## Department of Transportation

RE: SF2521 Kristin Estates Final Plat

Final Drainage Report for Kristin Estates, dated May 22, 2025, has been reviewed by a CDOT Hydraulic Engineer. Their comments are as follows:

DETENTION BASIN OUTLET STRUCTURE DESIGN

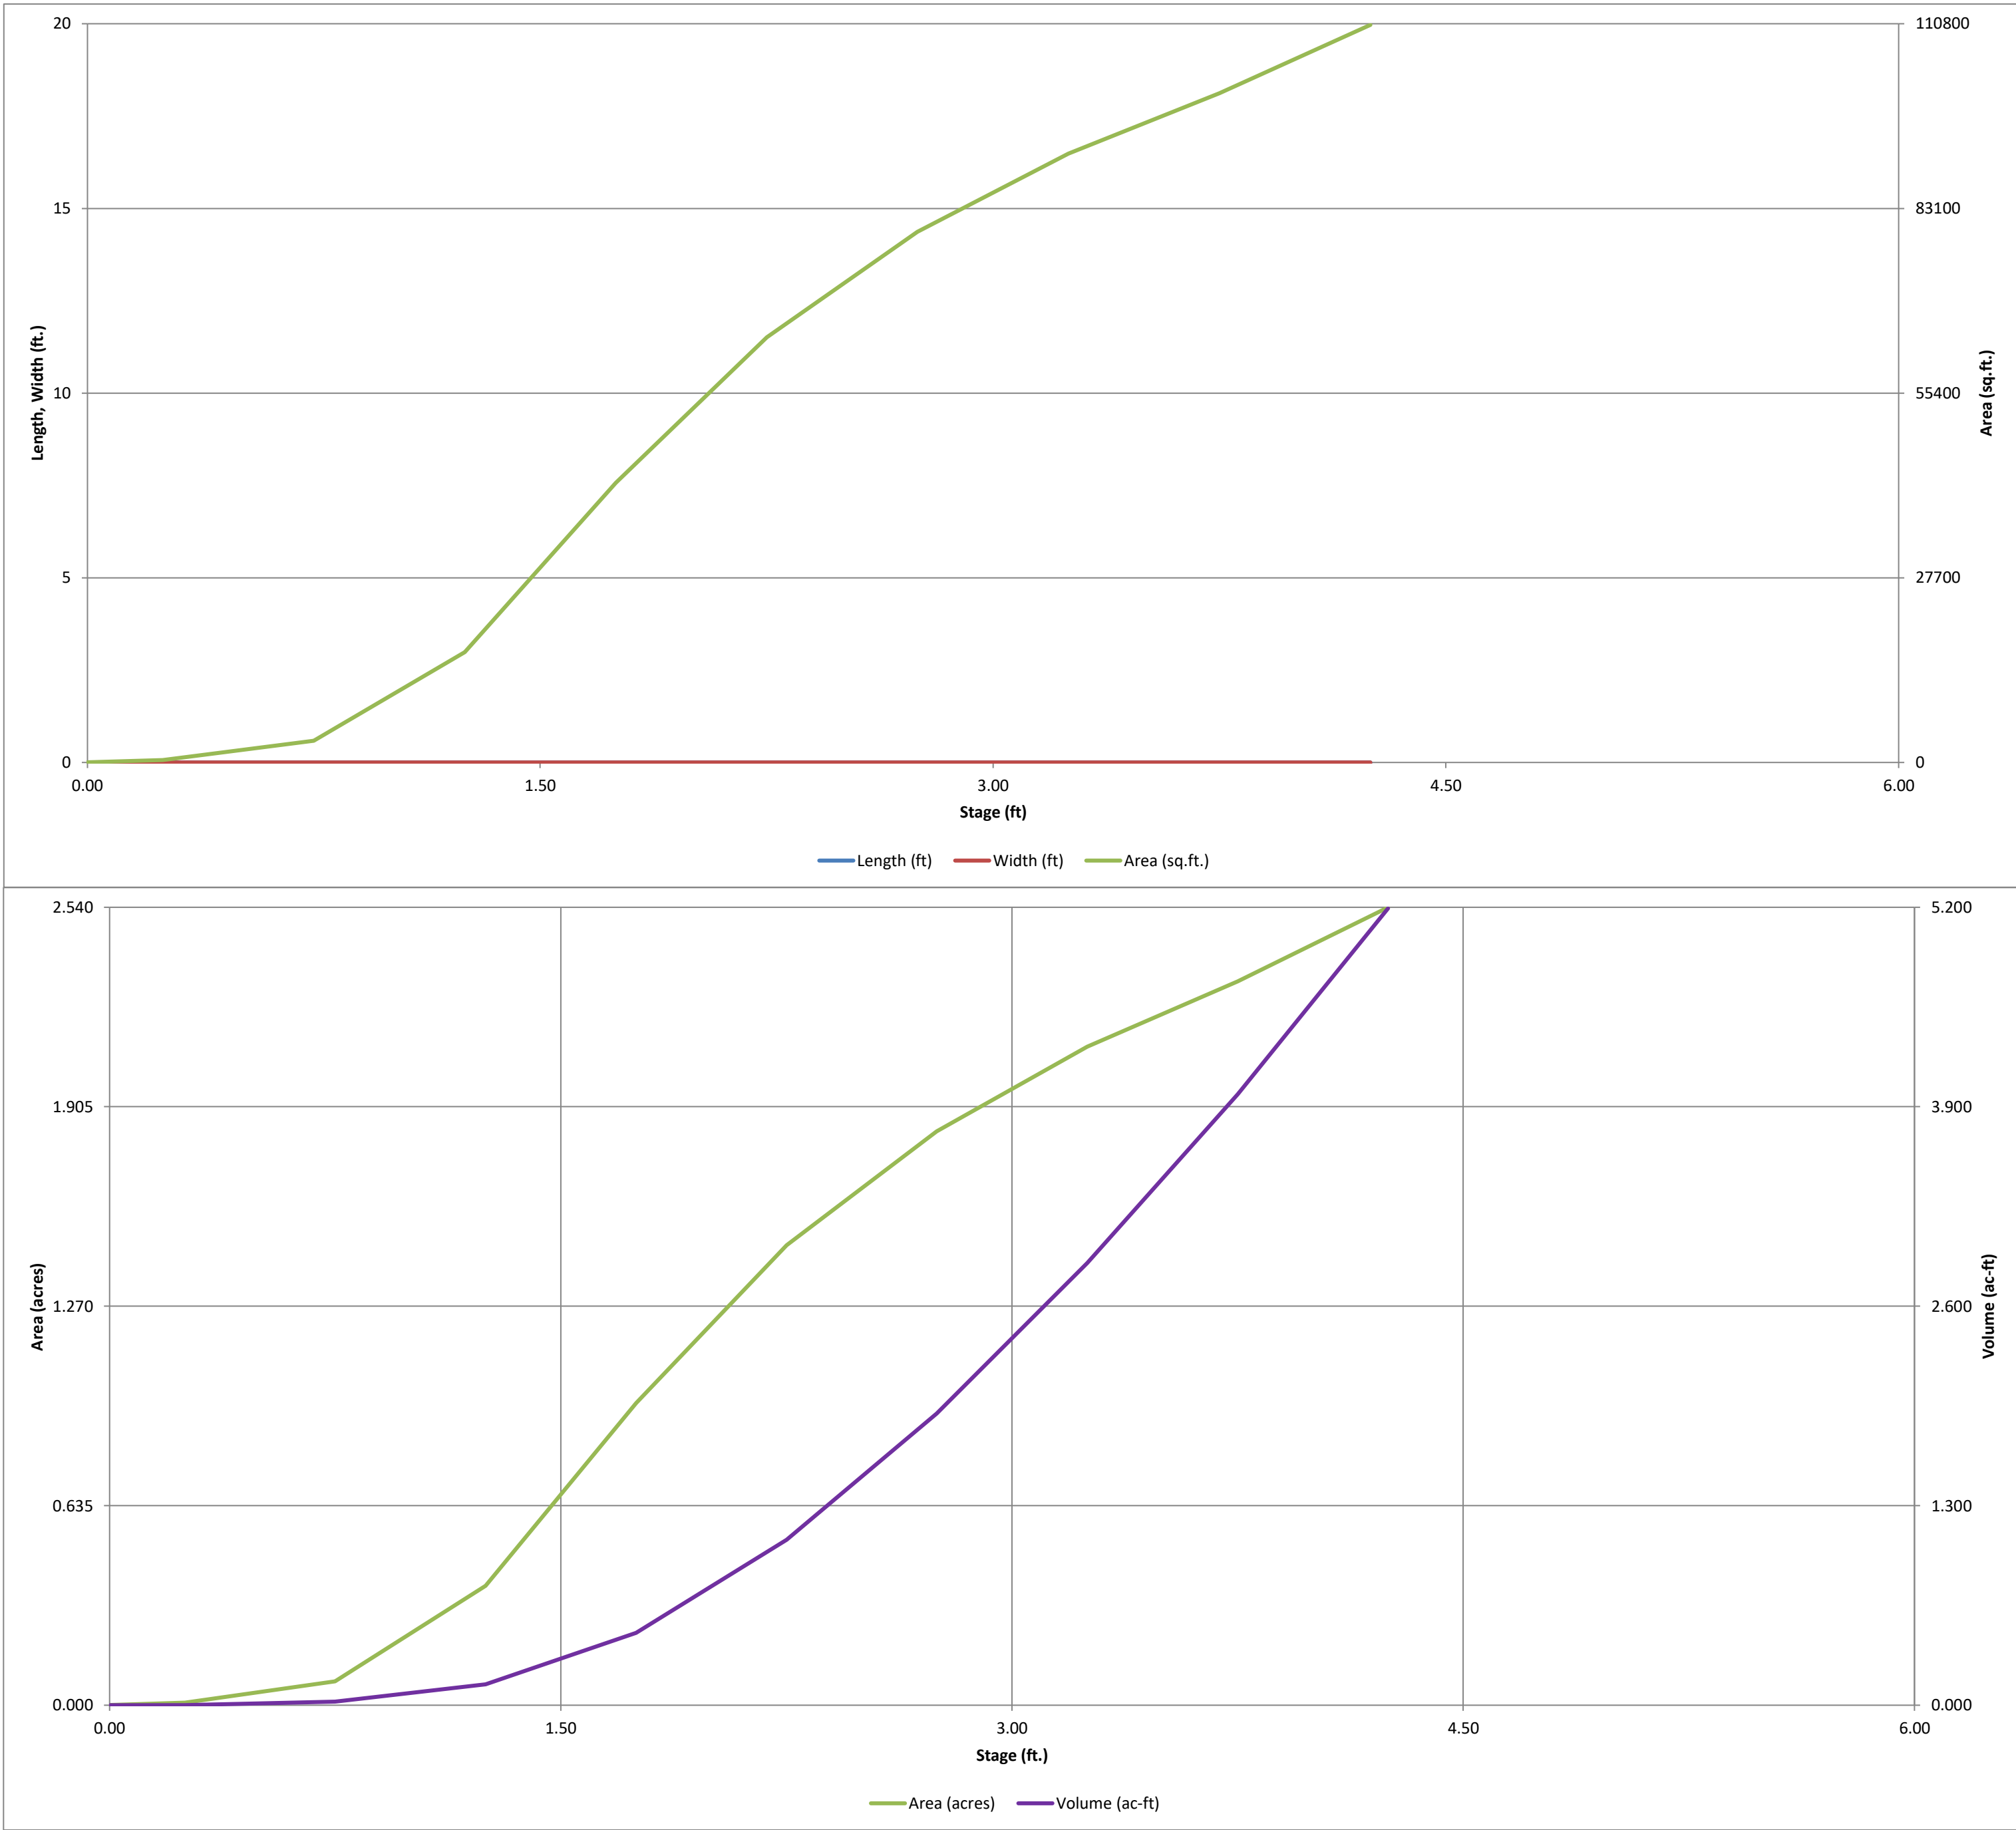
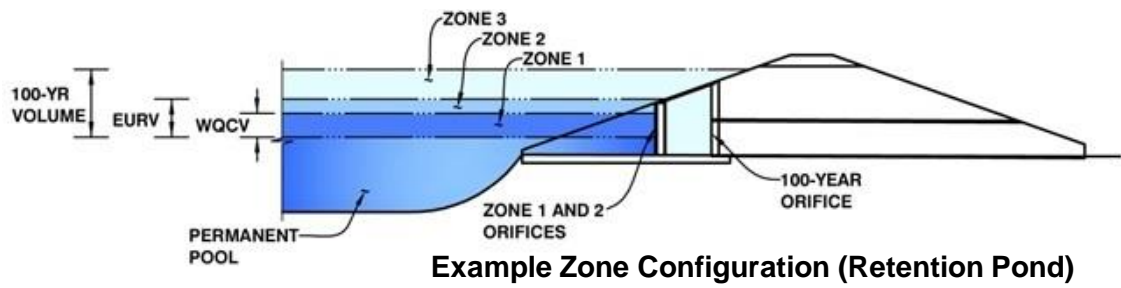
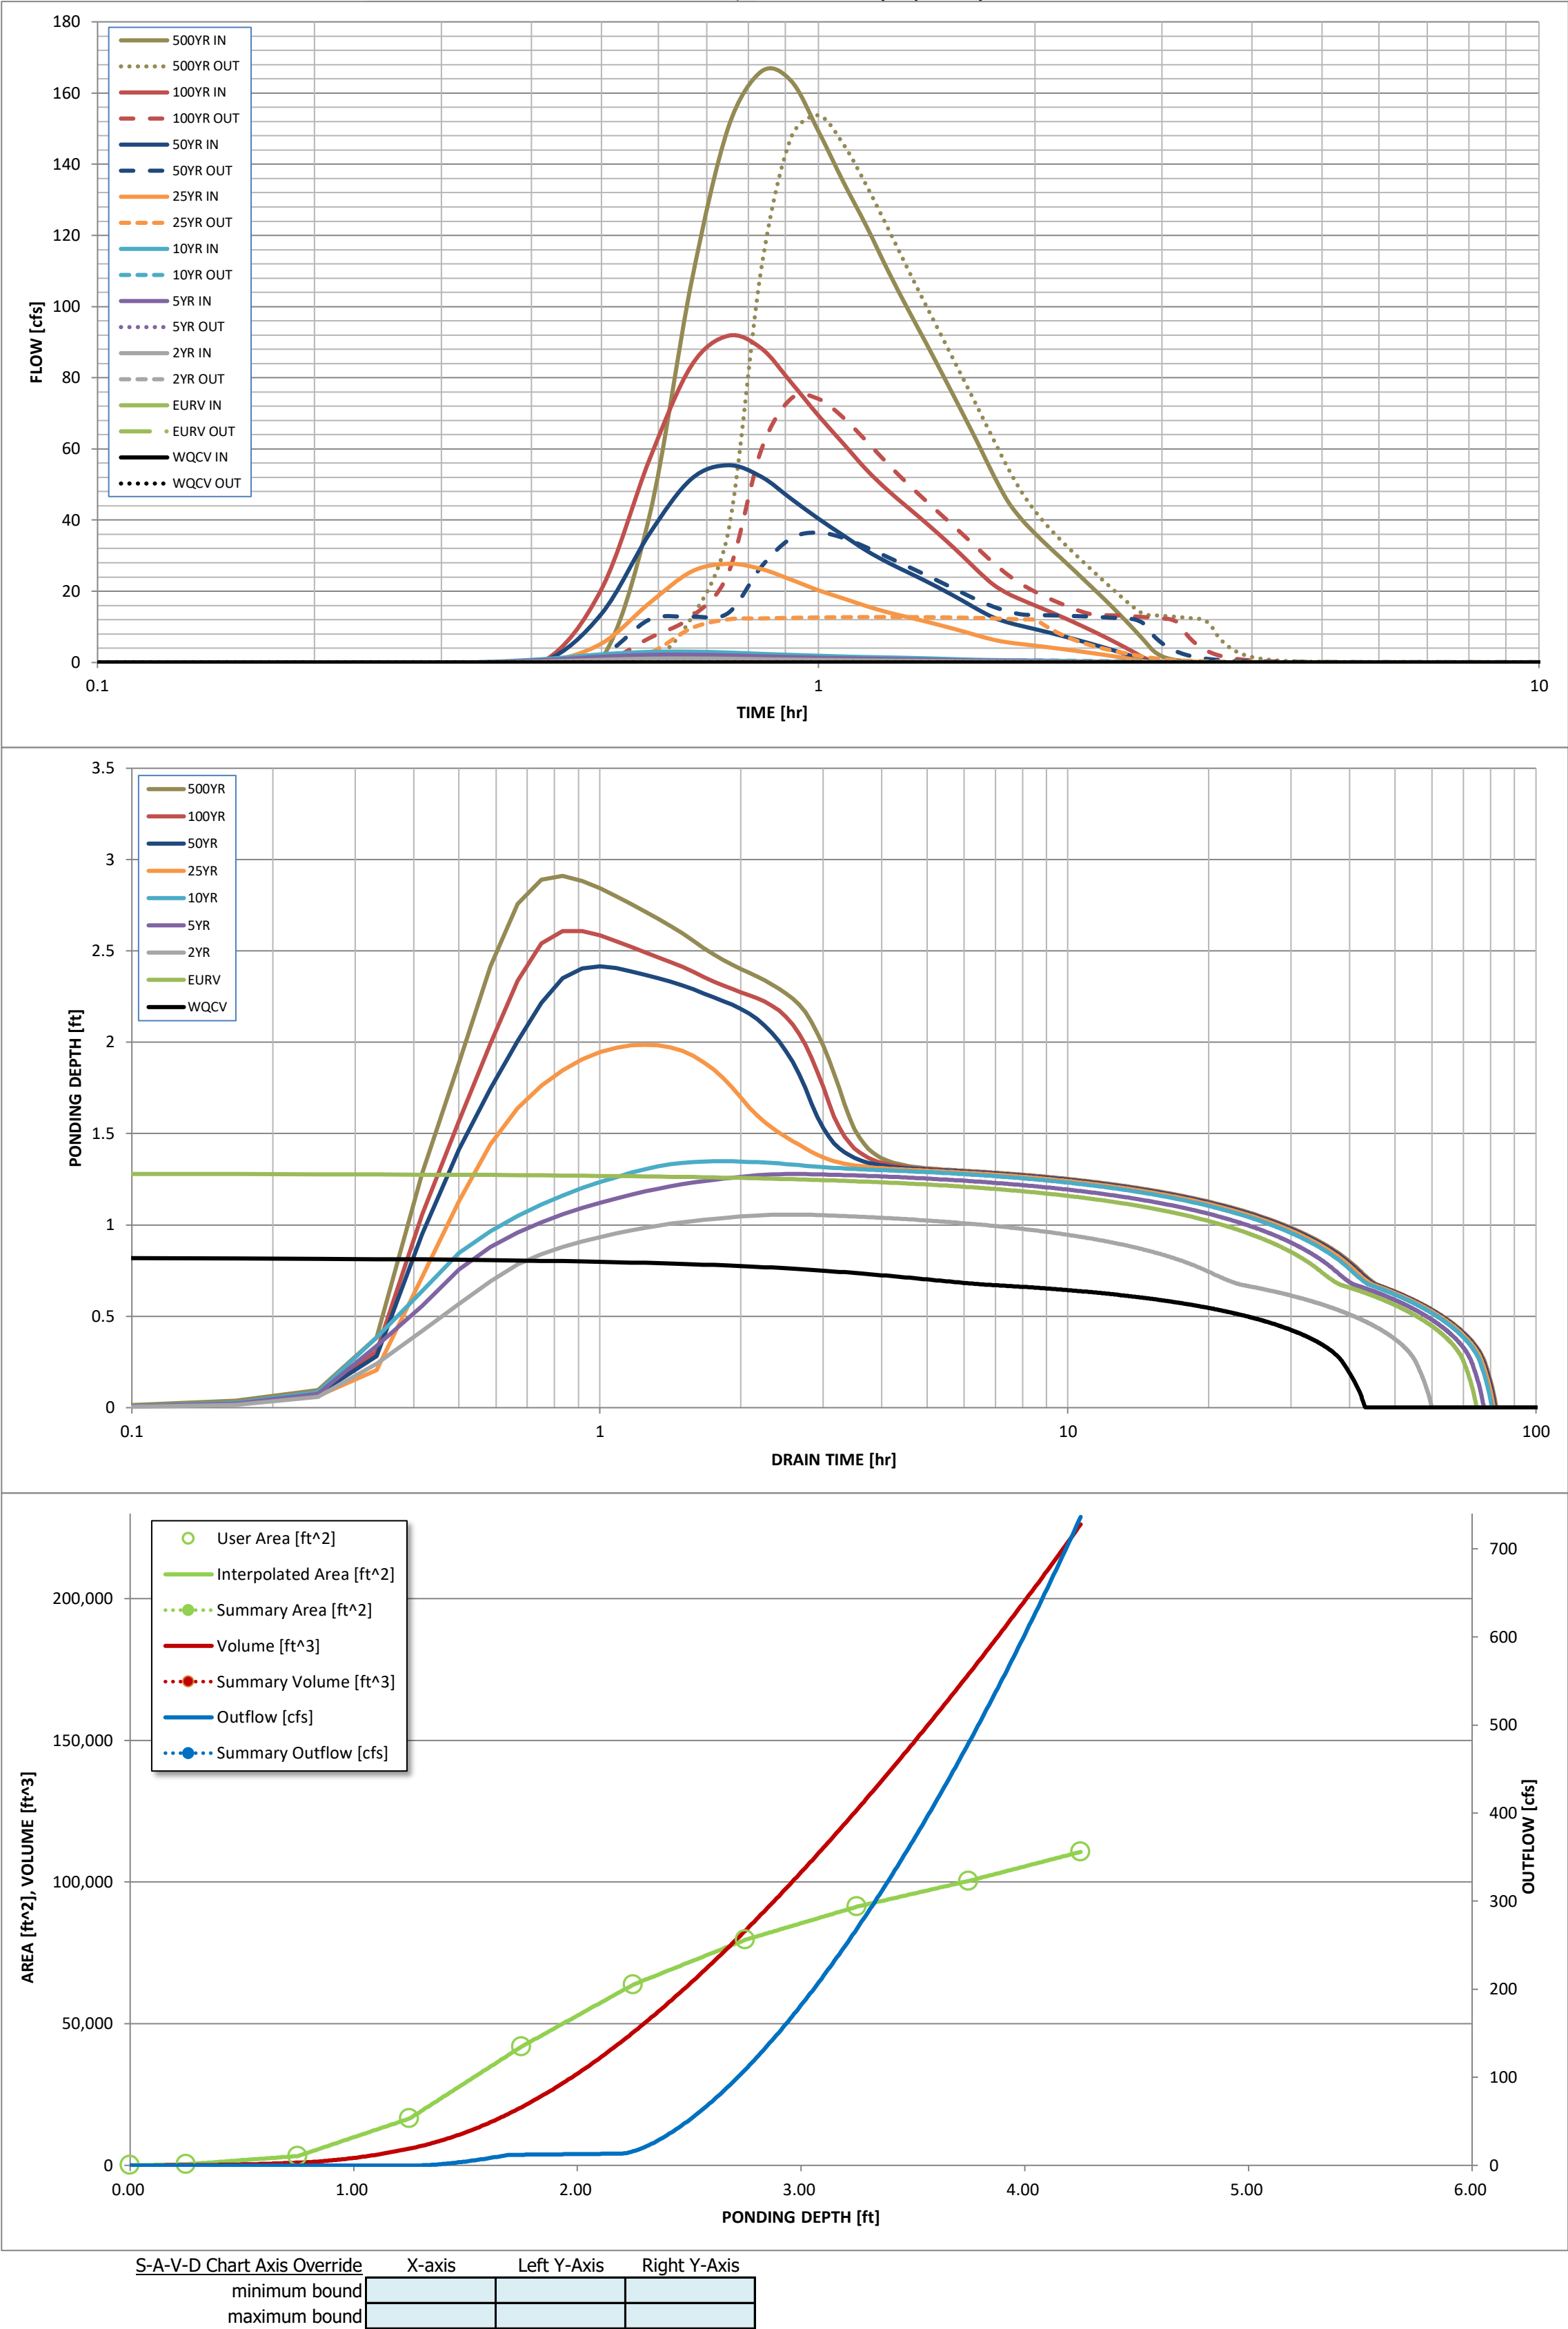
- PDF p 55 - The summary table includes existing offsite cumulative flows. Should these be revised for proposed cumulative flows?
- PDF p 59 - The detention spreadsheet shows that the 50-yr event will utilize the spillway. This is not discussed in the report.
- PDF p 71 - FYI the design discharge does not match the basin summary sheets.
- PDF p 72 - The design discharge for Culvert B is 21.36 cfs, which corresponds to DP OP4, however DP P4 is directly upstream of the culvert. How is the 13.12 cfs of Basin P4 accounted for with the culvert?
- PDF p 73 - The design discharge for the pond outlet pipe is 12.8 cfs. This corresponds to peak outflow for the 25-yr event on the pond design table (pdf p 59). Why was the 25-yr event used?

Revise the Final Drainage Report and resubmit.
